Cottam Solar Project

Pre-Examination Response to Section 51 Advice and Comments of the Planning Inspectorate: Cover Letter

PINS reference: EN010133
Document reference: PEX/C8.1
APFP Regulation 5(2)(q)

Planning Act 2008 - Application for a Development Consent Order for Cottam Solar Project
Application Ref: EN010133

Land Plans - Onshore
 Sheet 10 of 19

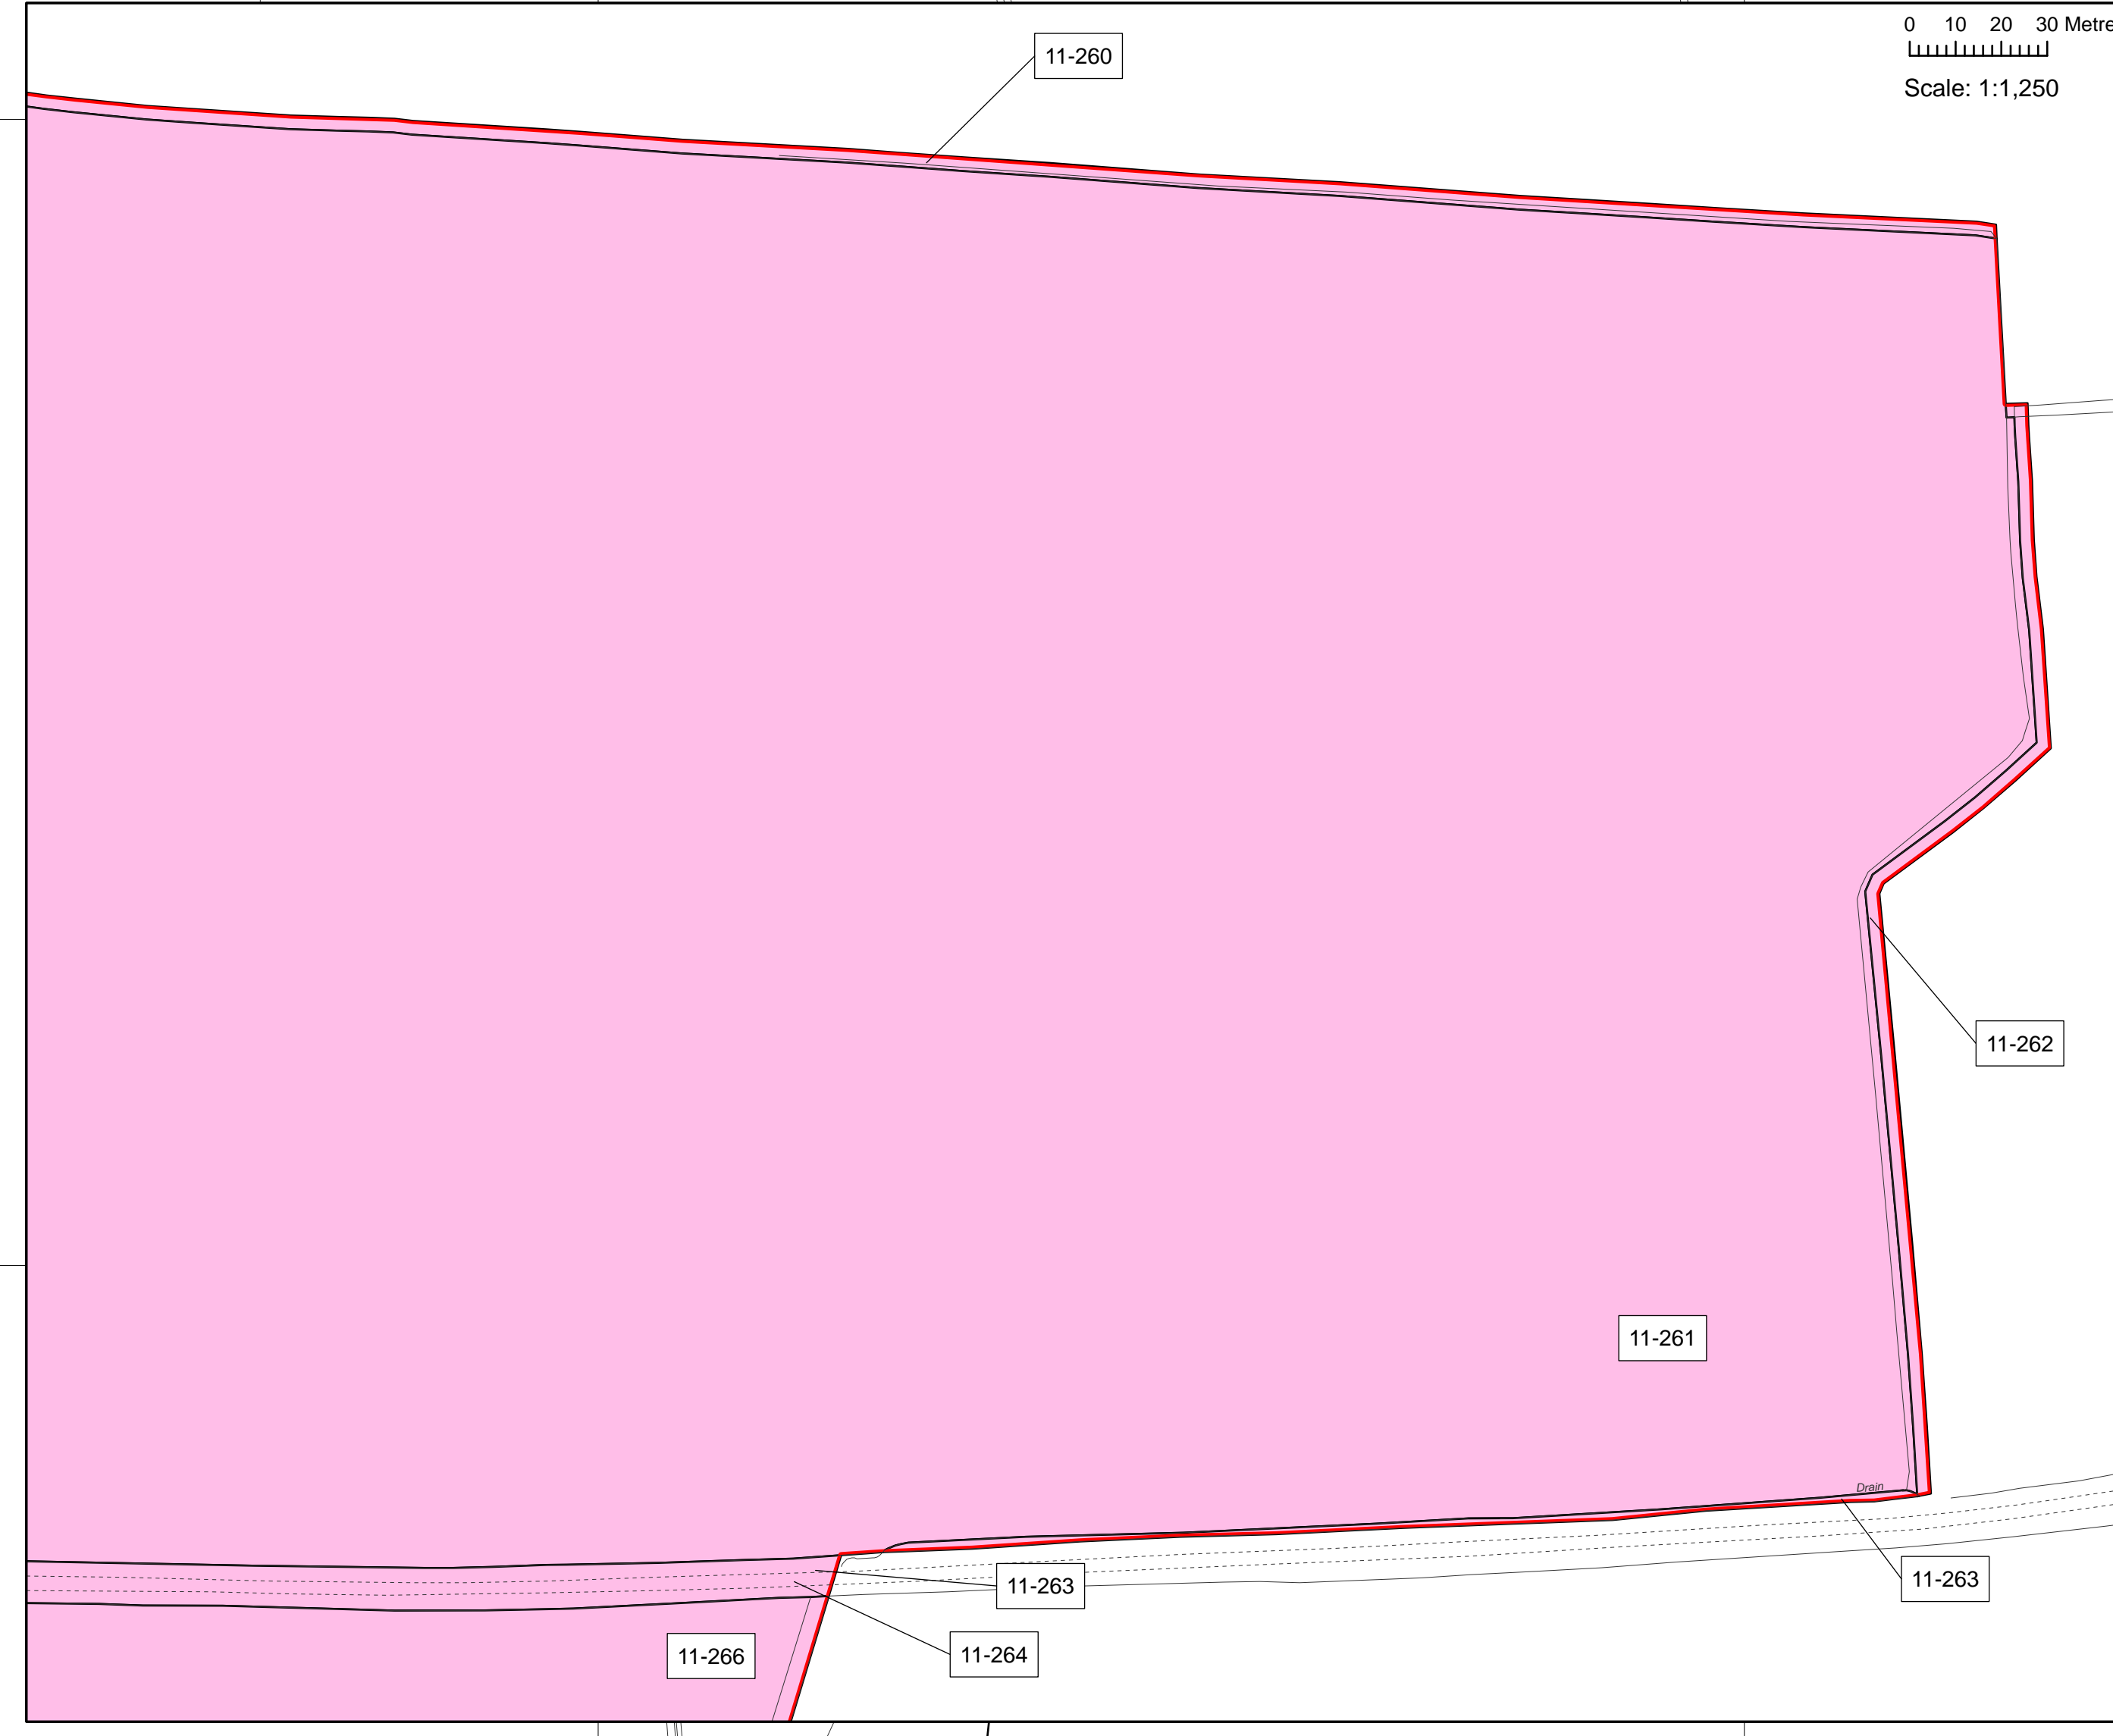
Work No 6A (viii) on Sheet 10 – noted in key plan but cannot see on plan	Yes	Shown on map. Added annotation to map to assist reader in identifying
	Work No 7A noted in key plan on sheet 15 but not on plan	Yes	Shown on map. Added annotation to map to assist reader in identifying
	Work No 9A noted in key plan on sheet 8 but not on plan	Yes	Works no. 9A feature hidden underneath 9B feature incorrectly. Now removed
	Work No 9B noted in key plan on sheet 19 but not on plan	Yes	Shown on map. Added annotation to map to assist reader in identifying
	No specific comment	Yes	Work no. 1A(iv) erroneously included area of Fleets Lane on Sheets 10 and 12. This is now corrected.
Street Plan	Not all road names are clearly identifiable.	Yes	We have reviewed the plans and these would appear to be adequate.

Land Plans
Sheet 15 of 19
Revision A

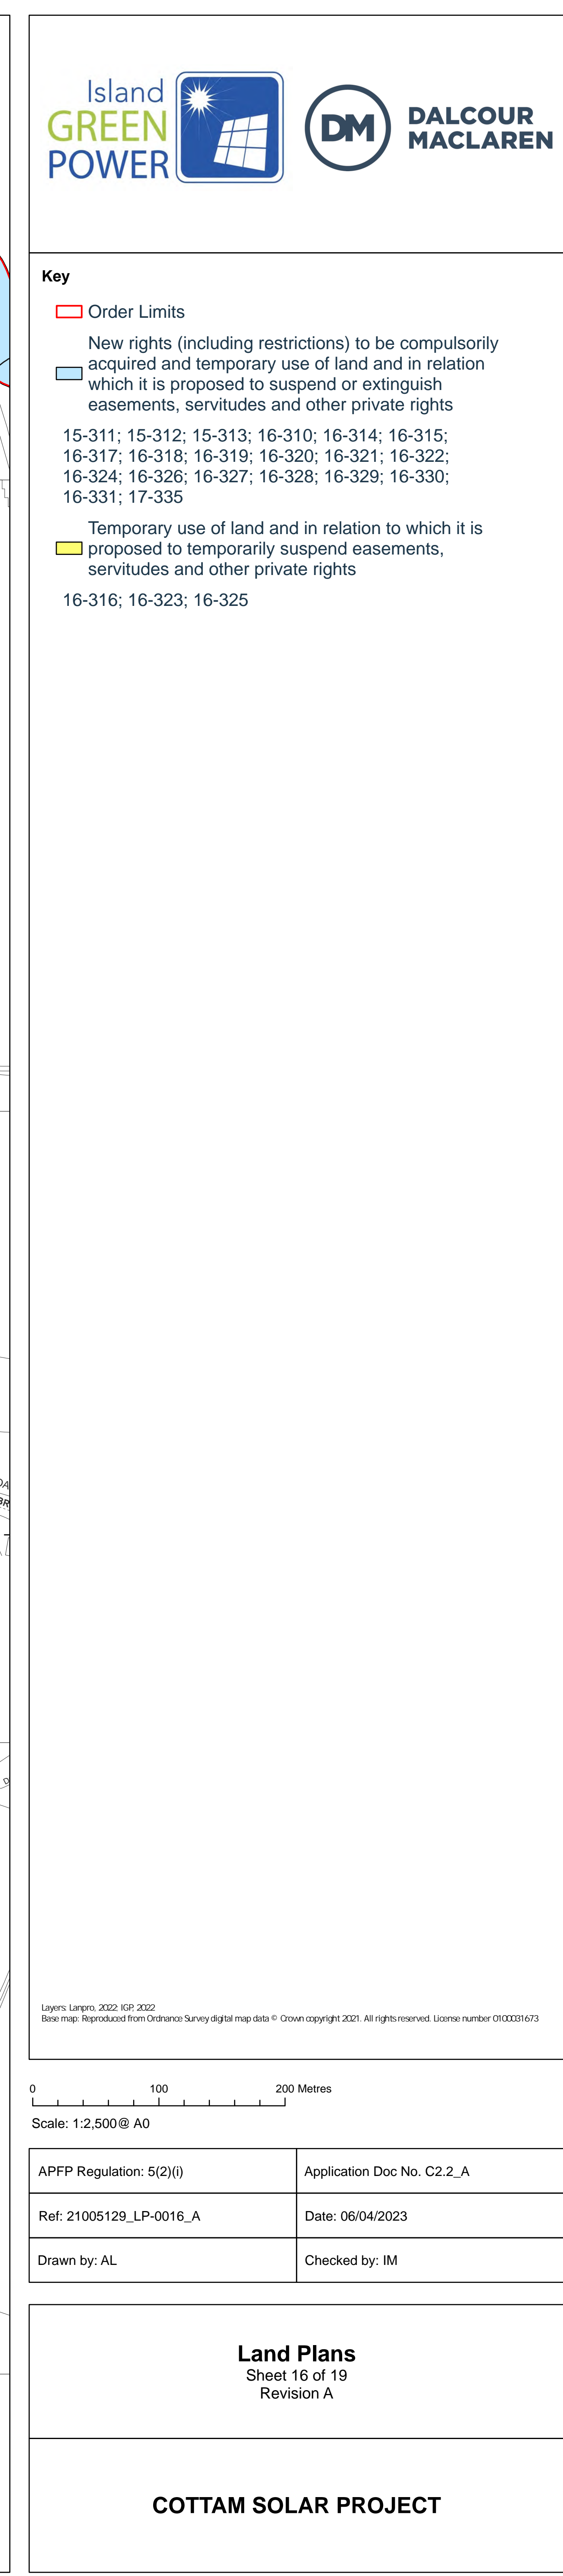
Planning Inspectorate Comment	The Applicant's Response
<ul style="list-style-type: none"> Plot 17-362 – Label missing on Sheet 17 but is labelled on sheet 18 [sic]. Not all road names are clearly identifiable. Plot 05-134 – may benefit from an inset. Plot (10-230 and 10-231 on sheet 15) Under key on plan as Freehold but not noted as Freehold in Statement of Reasons (Doc C4.1). Plot (10-244 on sheet 10) Under key on plan as Freehold but shown on plan as Acquisition of new rights and noted in Statement of Reasons (Doc C4.1) as Freehold and new rights. Plot (10-240 on sheet 10) Under key on plan as new rights but shown on plan and noted in Statement of Reasons (Doc C4.1) as Freehold but this is not shown as new rights in Draft Development Consent Order (Doc C3.1). Plot (10-241) Correct on plan as new rights but noted in Statement of Reasons (Doc C4.1) as Freehold but in the Draft Development Consent Order (Doc C3.1) it is shown as new rights. Plot 08-182 – As new rights on plan but not mentioned as new rights in SoR. In DCO as new rights. 	<p>Consequentially, updates have been provided to the Statement of Reasons [EN010133/APP/C4.1_A], and the Draft Development Consent Order [EN010133/APP/C3.1_A].</p>
